# CITY OF PORTLAND

Job ID: 2011-01-259-SIGN

49 Pine Street – Approved with conditions

## Deb Andrews - Cumberland Farms sign, 49 Pine Street, Portland

REVISIONS			6'x8' SINGLE POLE SIGN CONVERSION PLAN	SCALE: 1/2" = 1'-0"
DATE	REV. BY.	DESCRIPTION		
			Cumberland Farms, Inc. 90 SHIMMEL BLVD FRANKLIN, MA 02042	DATE: Dec. 23, 2010 FILE: LE02chgsout.dwg DRAWN BY: U.S.P. CHECKED BY:
			EXISTING/PROPOSED SIGN

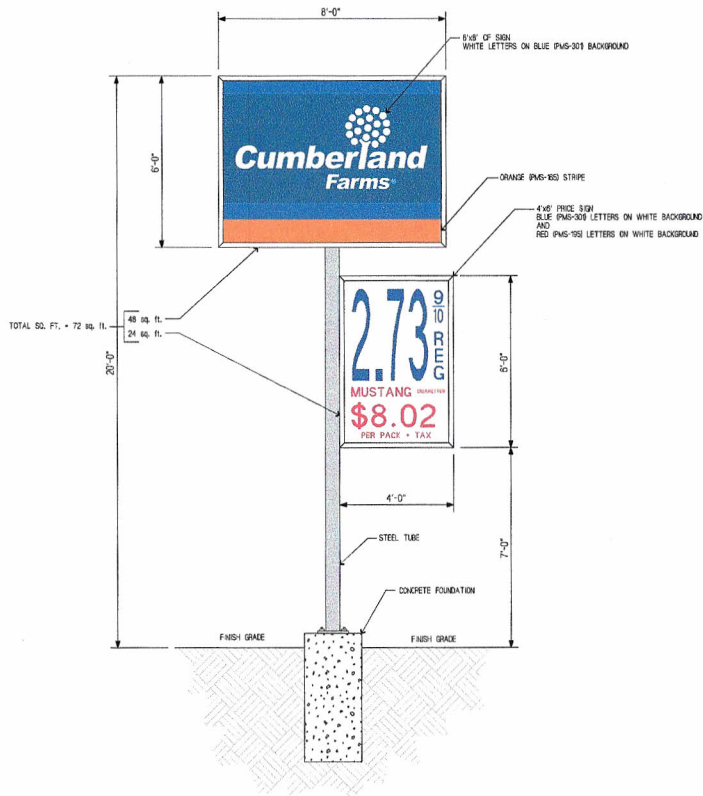
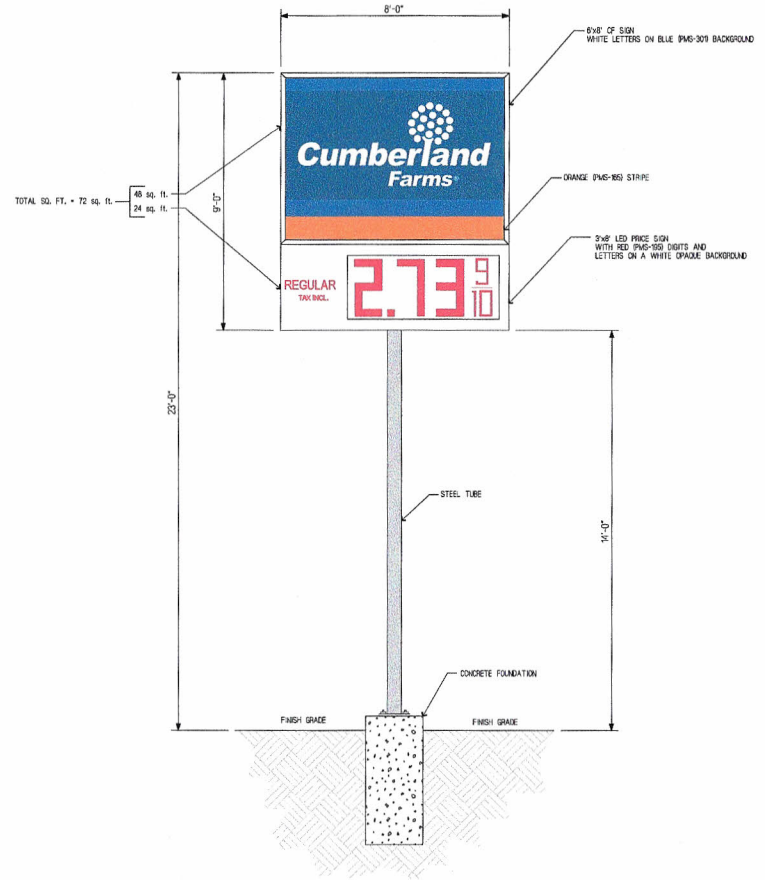
\* Is the upper "Cumberland Farms" cabinet proposed to be replaced as part of the project? To ensure that the new sign solution is consistent in character, I recommend that the upper cabinet be replaced as well and that the face of the cabinet be opaque (similar to the price panel below), with the letters, logo, and price screen routed to emit light.

\* The current and proposed square footage of the sign is 72 sq. ft (8' x 9'). Under current sign regulations, the maximum allowable sign area is 62 square feet. Although Cumberland Farms' current signage is grandfathered in terms of size, we ask that the overall size of the new, combined signage be limited to 62 square feet. This can be done by reducing the height of the price panel. As shown, the 2' high numbers in the price panel well exceed what is necessary for legibility in this location.

- Maintain height of 20'0" max per City
- Historic Zone additional fee zoning believes Hist Comm will be fine w/ it

1. ANY exterior work requires a separate review and approval thru Historic Preservation. This property is located within an Historic District.
2. This permit is being approved on the basis of revised plans submitted 2/3/11. Any deviations shall require a separate approval before starting that work.
3. The existing sign is legally nonconforming at 72 square feet. The new sign (revised proposal) now meets the maximum required square footage of 62 square feet. Any future sign must also meet this maximum requirement. The height of the existing sign is 20' which is nonconforming. The proposed sign may not be higher than 20' from grade to the top of the sign.

1. Approved on basis of revised proposal received 2/3/2011. Approved with the understanding that the background faces of both the upper and lower panels will be opaque, with only the logo/letters/numbers illuminated.
